Office of
Environment
& Heritage

Our Ref. DOC16/558641
Your Ref. SSD 0127 Mod 5

Invincible Coal Mine – Southern Extension Modification (SSD 0127 Mod 5)

FIGURE 2.1
Flora Survey Locations

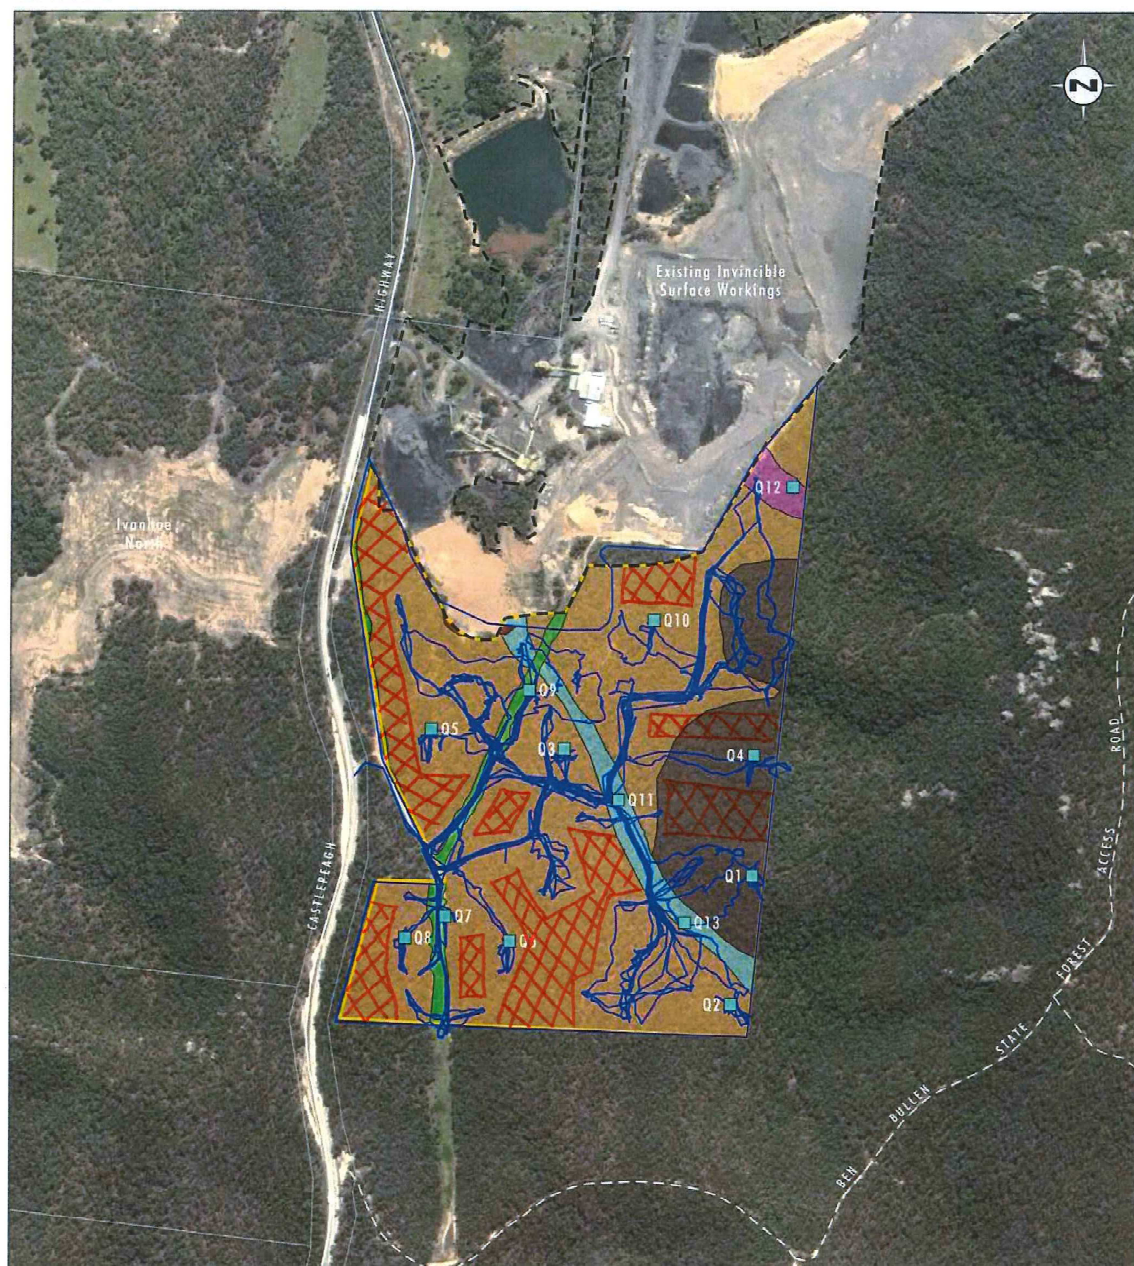
Twenty four individuals of *E. cannonii* are reported to occur across five locations in the Southern Extension Area. Figure 2.1 provides details of flora survey locations and flora survey tracks. Table 2.4 indicates that the search effort for *E. cannonii* entailed general meandering searches. OEH has concerns that this survey effort is insufficient to detect all *E. cannonii* trees within the Project Area as there appears to be areas where survey has not been undertaken.
